**Deadline VI submissions**

<p>Referenced by ExA second round questions.</p>	<p>LBH Comments; Response to HE Deadline V comments</p>
<p><b><u>4. Environment</u></b></p>	
<p><b>Landscape and Visual Effects</b></p>	
<p>4.2.1</p>	<p>The council maintains that the impact on Cranford Park is significant and warrants appropriate mitigation.</p> <p>Drawing no. 514451-MUH-00-ZZ-RP-EN-300374 (Enhanced Mitigation Strategy) identifies in pink that 'existing replacement noise barriers' will be provided along the southern stretch of the M4 adjoining Cranford Park, however this plan provides no clarity on whether this 'pink line' refers to replacement noise barriers and if it is to be replaced, what the proposed height of this barrier is- this requires full clarification and explanation and until this received, it is maintained that this scheme has a detrimental impact on the heritage assets of Cranford Park in the absence of appropriate mitigation being in place. It is noted that the HE written submission at Deadline V does state that a 2metre acoustic fence is propose in this location, hwoever the plans, which are to be approved do not provide any such clarity.</p> <p>With regard to the photo

Figure 1: NO₂ Projections Informing IAN 170/12 v3

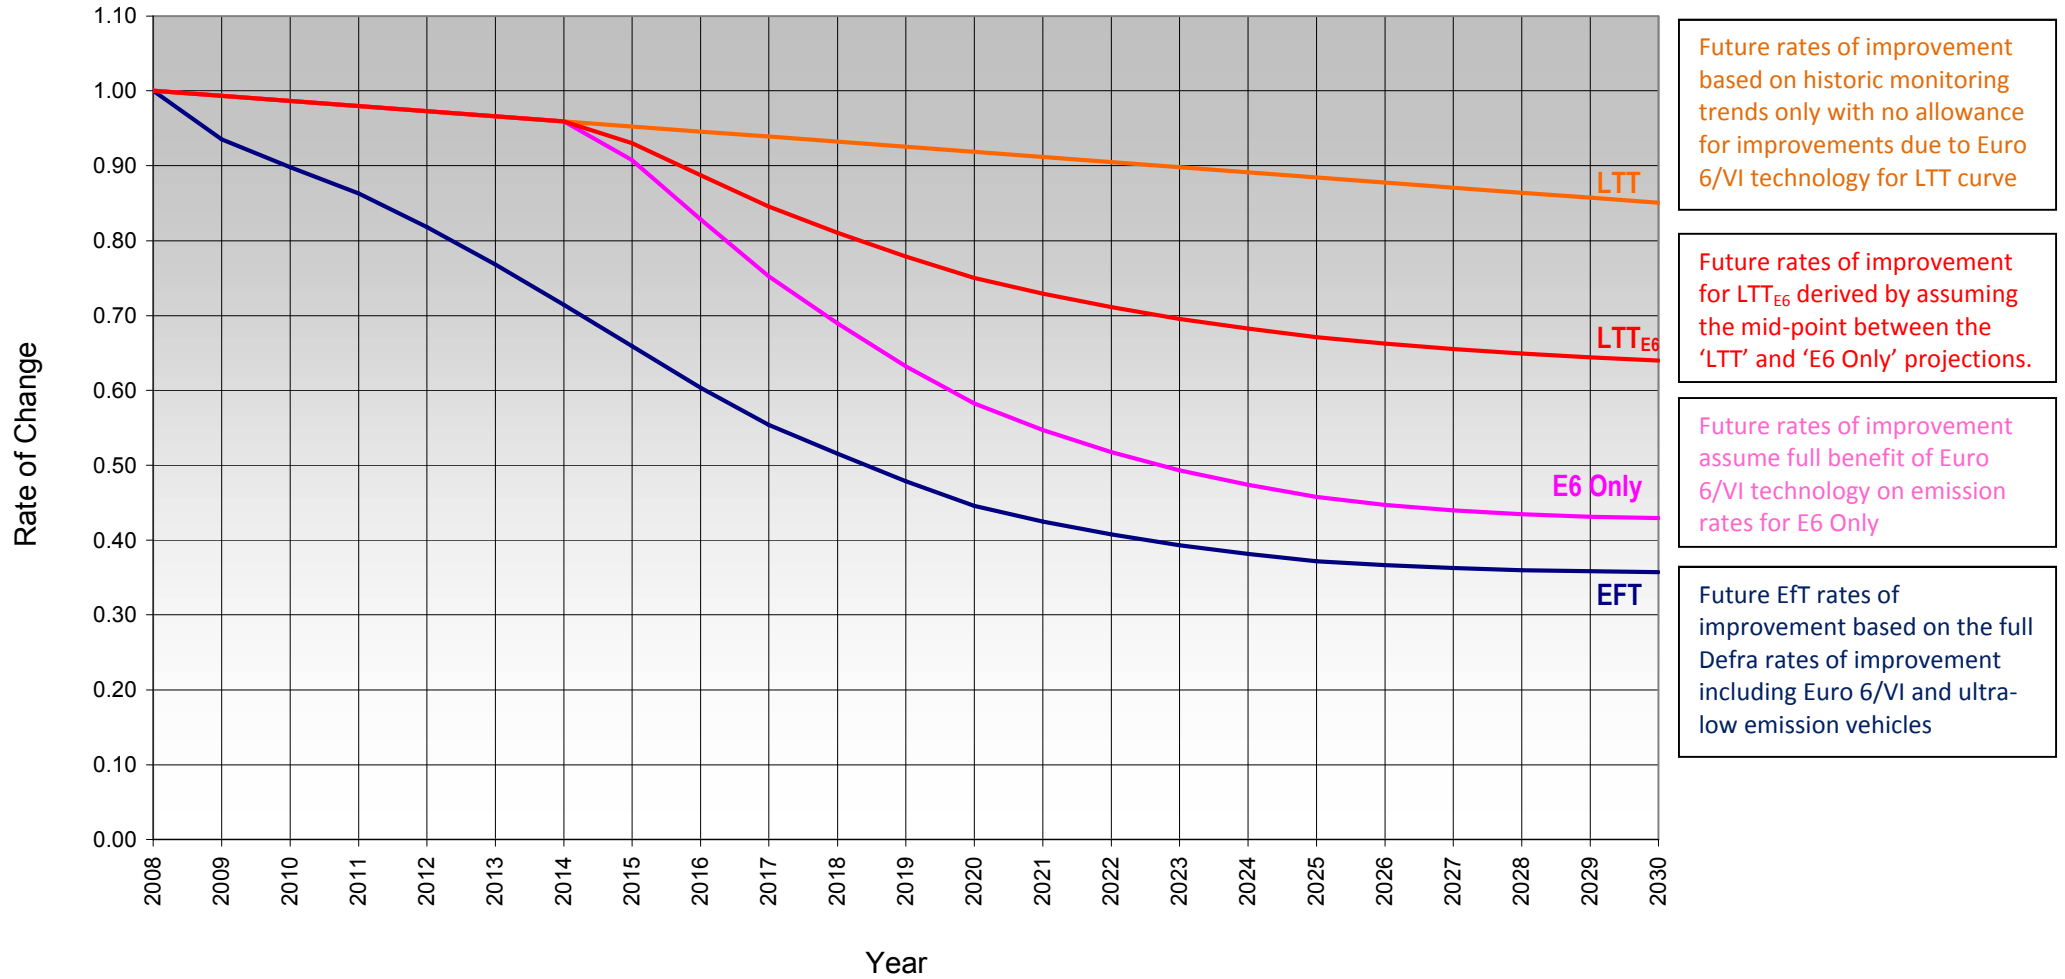
4.6.4	<p>Various references are made in this section to the use of the LTTE6 results providing a more conservative assessment than the Defra projections. The basis of the LTTE6 results is illustrated in the graph presented by HE to the ExA at the November Hearings (Appendix E – Derivation of LTTE6 Used in the Environmental Statement). No further details have been provided by HE on the derivation of the curves in this Figure, despite requests. It is understood that the LTTE6 results have been arbitrarily chosen to lie half way between those of the original LTT approach (the trend from monitoring data) and the E6Only approach, which assumes that Euro 6/IV vehicles deliver as expected. In practice, it would be expected that the E6Only approach would equate to the use of Defra’s EFT which assumes Euro 6/IV vehicles deliver as expected. This expectation is not however borne out in the results presented by HE in the ES. To take an example based on the results for receptor X9 (all values presented are base values, without scheme, as presented in the ES, i.e. not calibrated against the AURN alone, which would give higher values): the nitrogen dioxide concentration in 2013 is 46.8 <math>\mu\text{g}/\text{m}^3</math>, in 2022 the concentration using the EFT becomes 34.4 <math>\mu\text{g}/\text{m}^3</math> and 36.2 <math>\mu\text{g}/\text{m}^3</math> with the LTTE6. Using the LTT approach the 2022 value would have been 43.8 <math>\mu\text{g}/\text{m}^3</math>. If the logic of the LTTE6 worst-case approach were to apply the value should fall halfway between 43.8 <math>\mu\text{g}/\text{m}^3</math> and 34.4 <math>\mu\text{g}/\text{m}^3</math>, i.e. 39.1 <math>\mu\text{g}/\text{m}^3</math>, not 36.2 <math>\mu\text{g}/\text{m}^3</math>. HE does not seem to be applying the logic underlying its recommendation to use LTTE6 as a worst case approach. It therefore appears to be underestimating the ‘worst-case’ concentrations, further emphasising the risk that future concentrations may be higher than assessed.</p>
